Application No: EP/67/20/PL
Site Address: Land adjacent to 45 The Ridings East Preston BN16 2TW
Description of works: 1 No. detached house & formation of associated new access.

Thank you for your internet representation made on 8th July 2020 which has been recorded as an objection with the comments as follows:

DRAWING TITLE
PROPOSED SITE LAYOUT

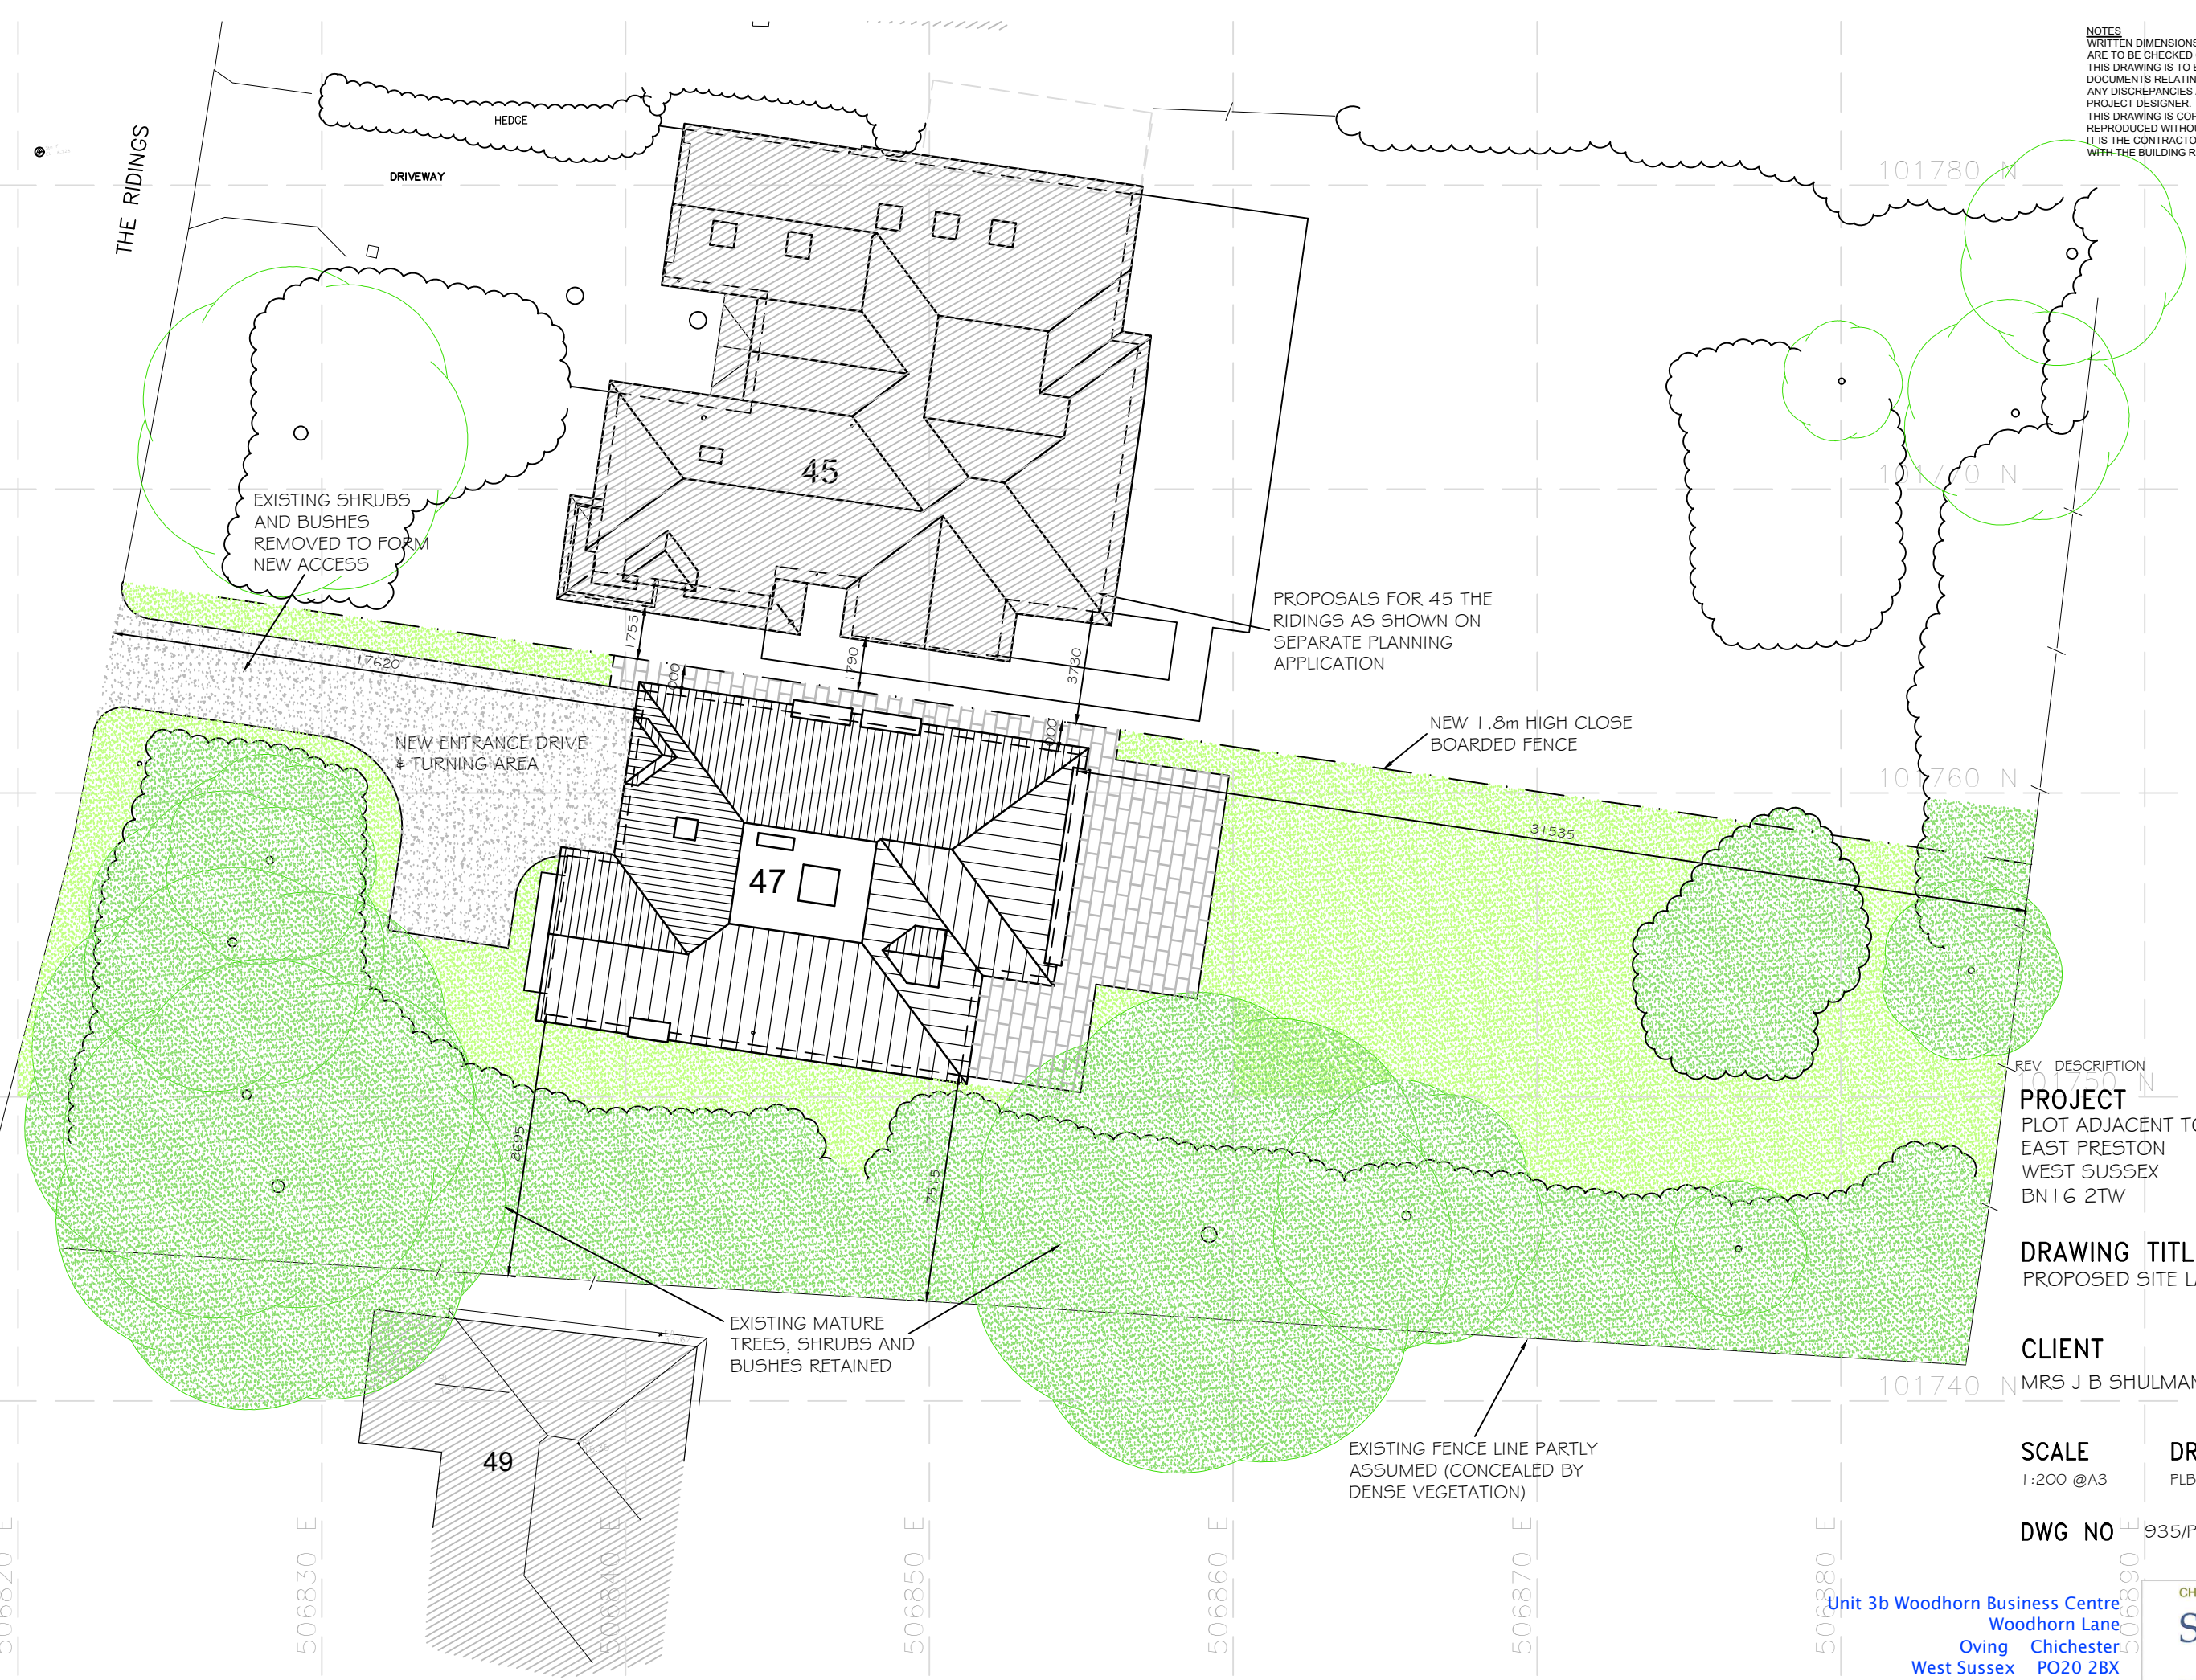
The committee was concerned a property of this size would realistically likely generate a need for more parking spaces than the three required.

There was also some concern expressed about the proximity of the new building to the northern boundary. As this boundary will be better seen from the road than the southern boundary, there was concern this would appear cramped when there is enough space on the site to have the northern elevation further away from the northern boundary of the plot.
